City of Albuquerque Stormwater Construction Site Inspection Report

| Project Name and Location | Entertainment Facility 3930 Pan American Frwy | | |
| Site Contact Name & Agency | Max Kruichak Jaynes Corporation max.kruichak@jaynescorp.com | ESC File No. NPDES ID No. | G16E145A NMR1001MP NMR100161 |
| Date of Inspection | 11/01/18 | Start/End Time | 1:35pm 2:15pm |

RONALD R. BOHANNAN P.E. #7868	ENTERTAINMENT FACILITY 3930 PAN AMERICAN FRWY	DRAWN BY pm
		DATE 2-1-18
	SWPPP	DRAWING
	 TERRA WEST, LLC 5571 MIDWAY PARK PL NE ALBUQUERQUE, NEW MEXICO 87109 (505) 858-3100 www.tierrowestllc.com	SHEET # 8 JOB # 2017042

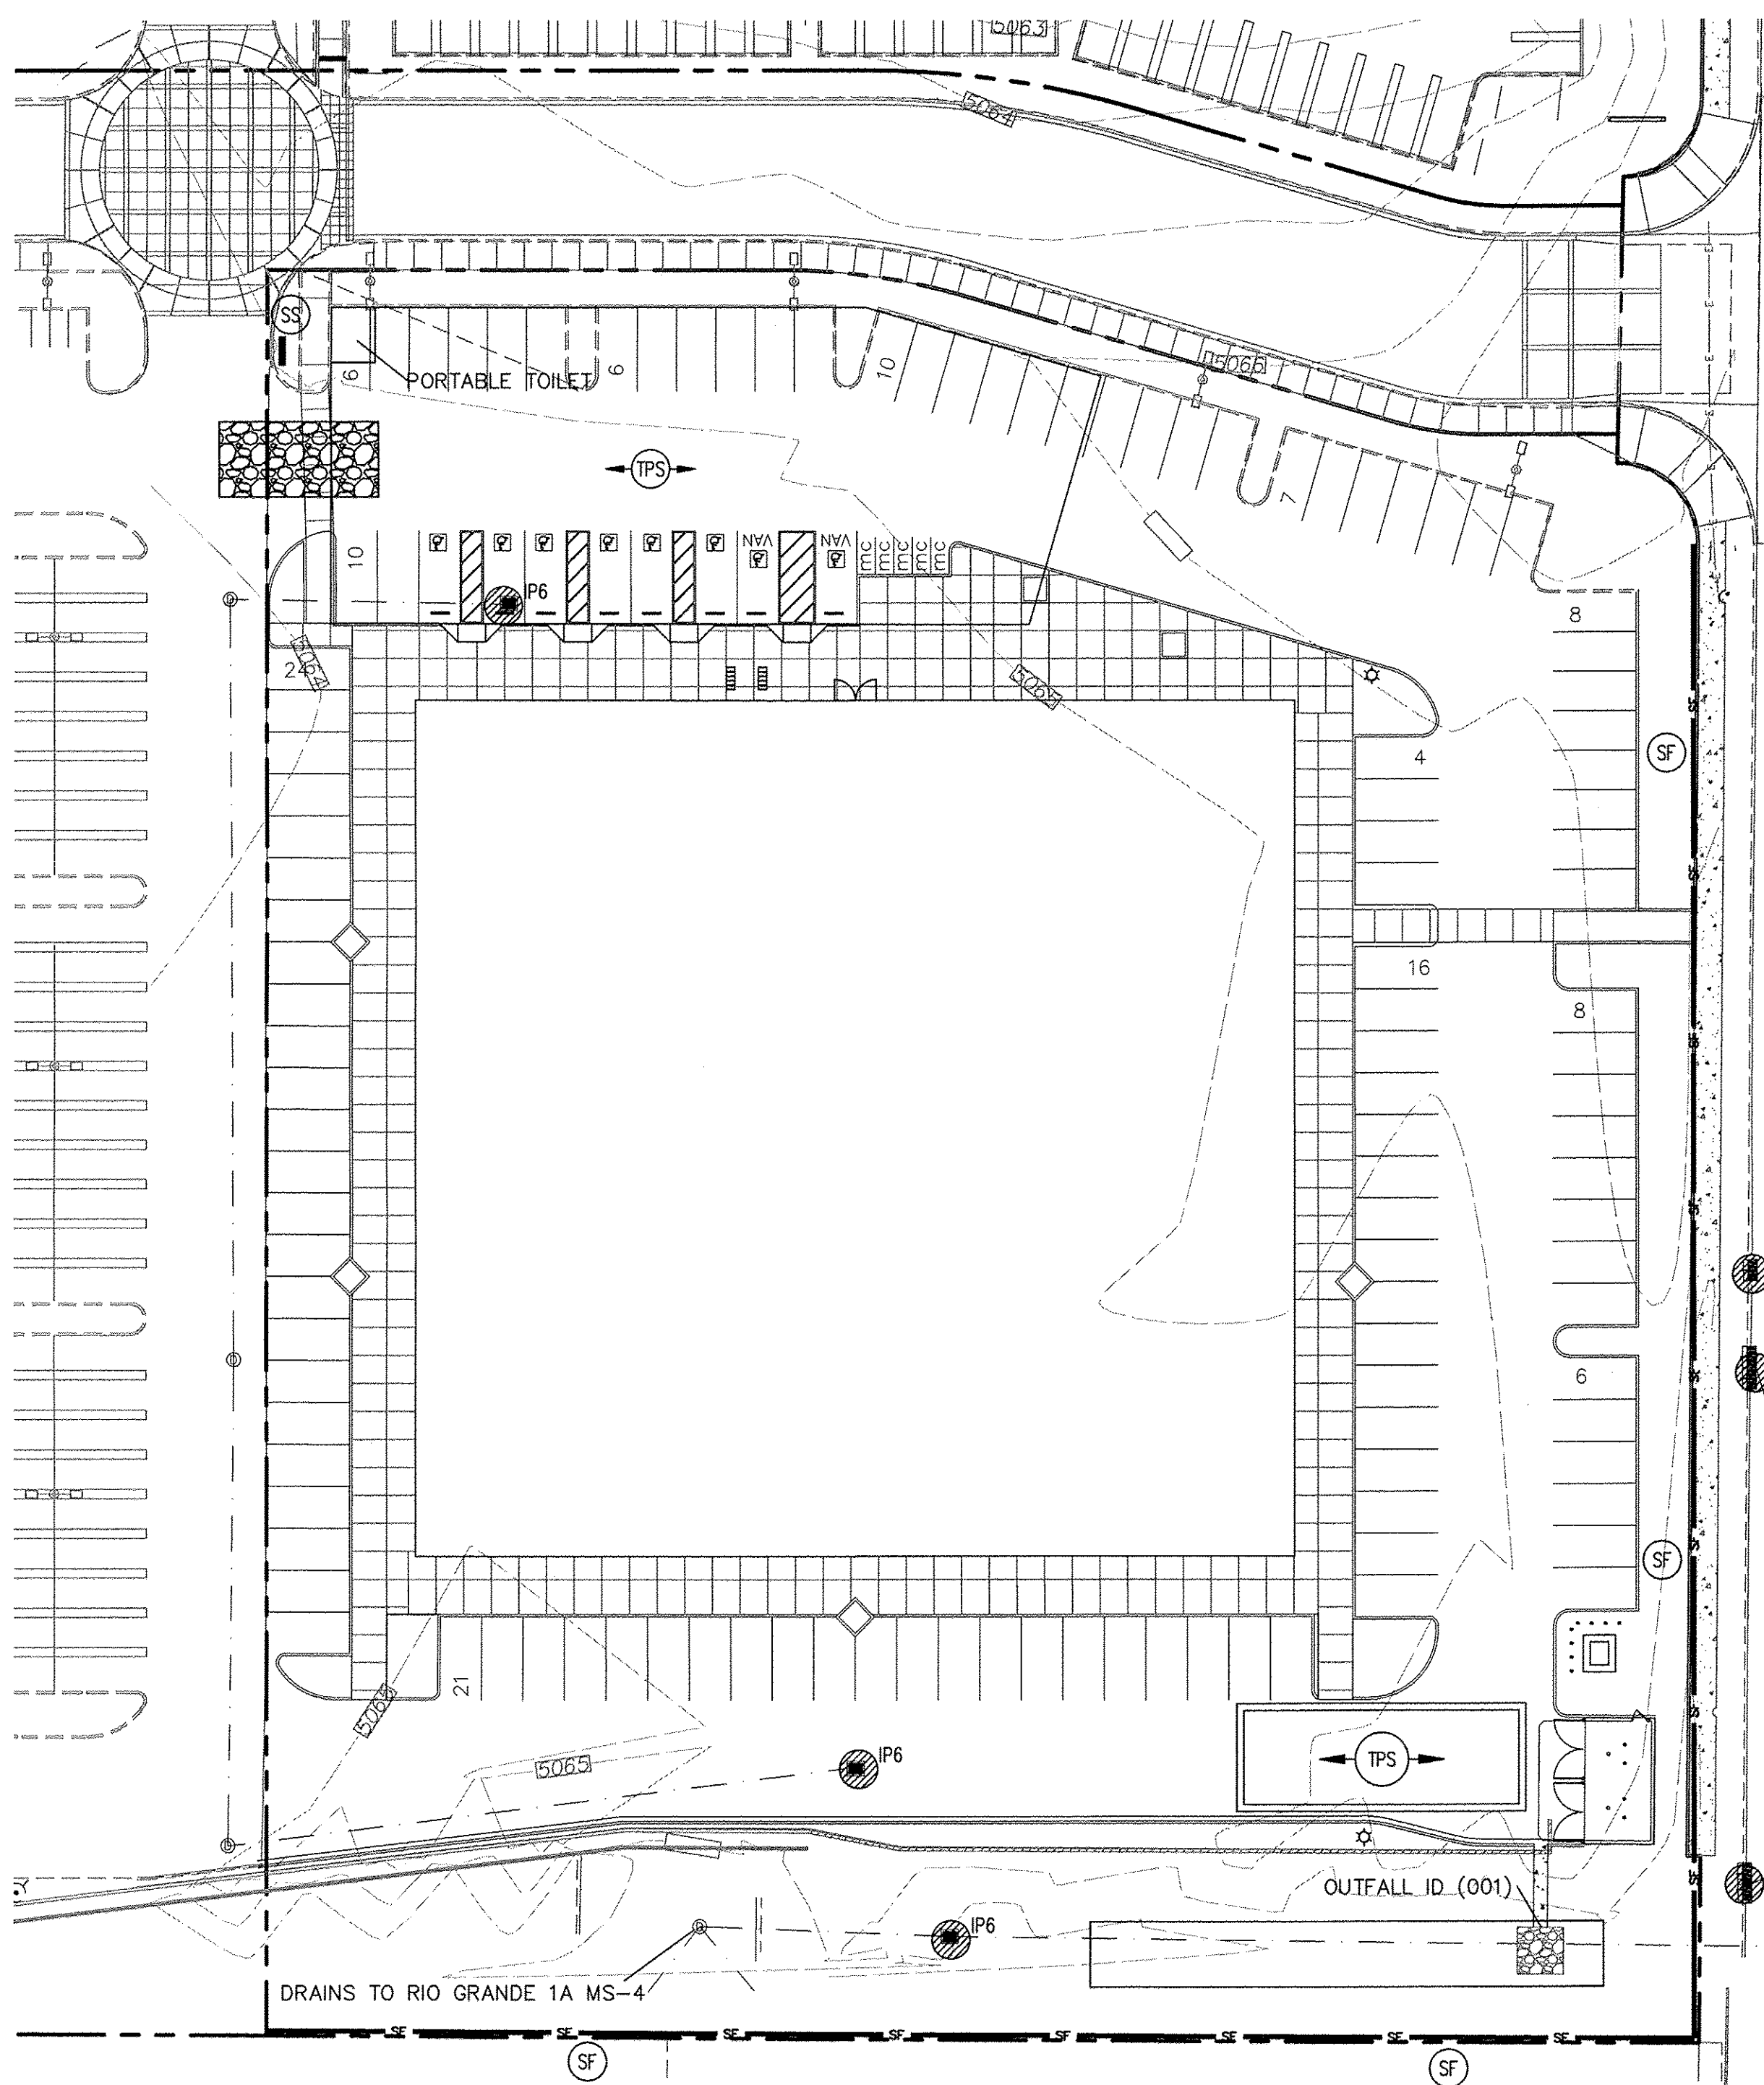
| CGP | BMP / Activity | Maintenance Required? (1) | Corrective Action Required? (2) | Location and Notes |
|-------|---|---------------------------|---------------------------------|--------------------------------------|
| 2.2.3 | Sediment control along any perimeter | | Yes | BMP is required at SW Corner of site |
| 2.2.4 | Minimize sediment track-out | Yes | | Provide Trackout Maintenance |

| 2.2.10 | Protect Storm Drain Inlets | | Yes | Cover inlet in CUTC Parking Lot |

Please address the corrective actions within 7 days. Please email pictures of the corrections.
